Our Ref: BE/151/11/

5th January 2012

Extension to existing caravan park to provide 12no. additional mobile homes, associated parking area, formation of access and construction of electrical intake housing -
Amendment to application BE/42/10

Land South of Shripney Garden Caravan Park, Shripney Lane Bognor Regis

SHRIPNEY GARDEN CARAVAN PARK, SHRIPNEY LANE, SHRIPNEY
Proposals 01
Nov 2011

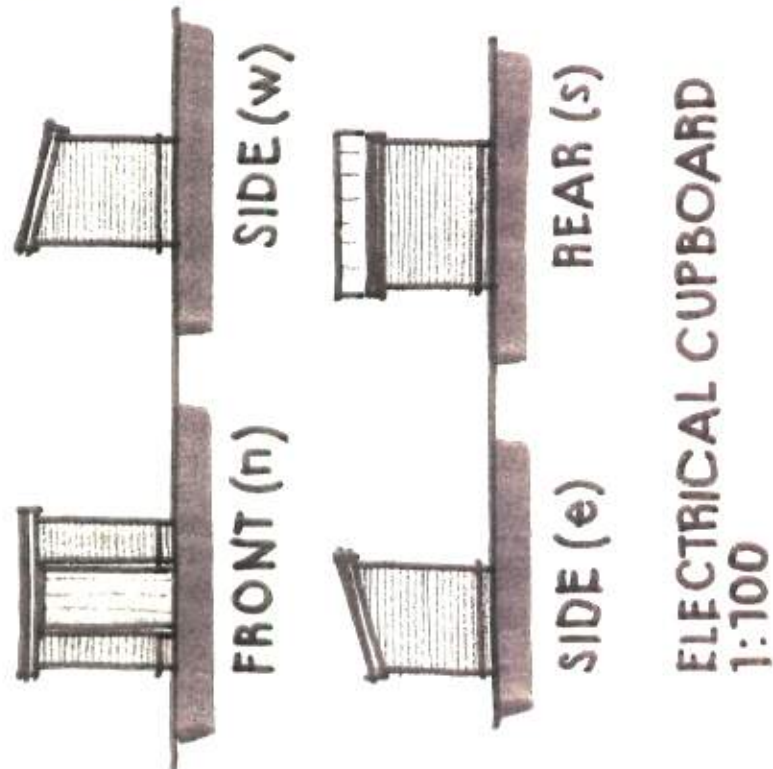
The parish council objects for the following reason, the new plan varies from the original regarding the layout position of the caravans which are intrusive to the neighbouring properties. We have also received 9 letters of objection from local residents.
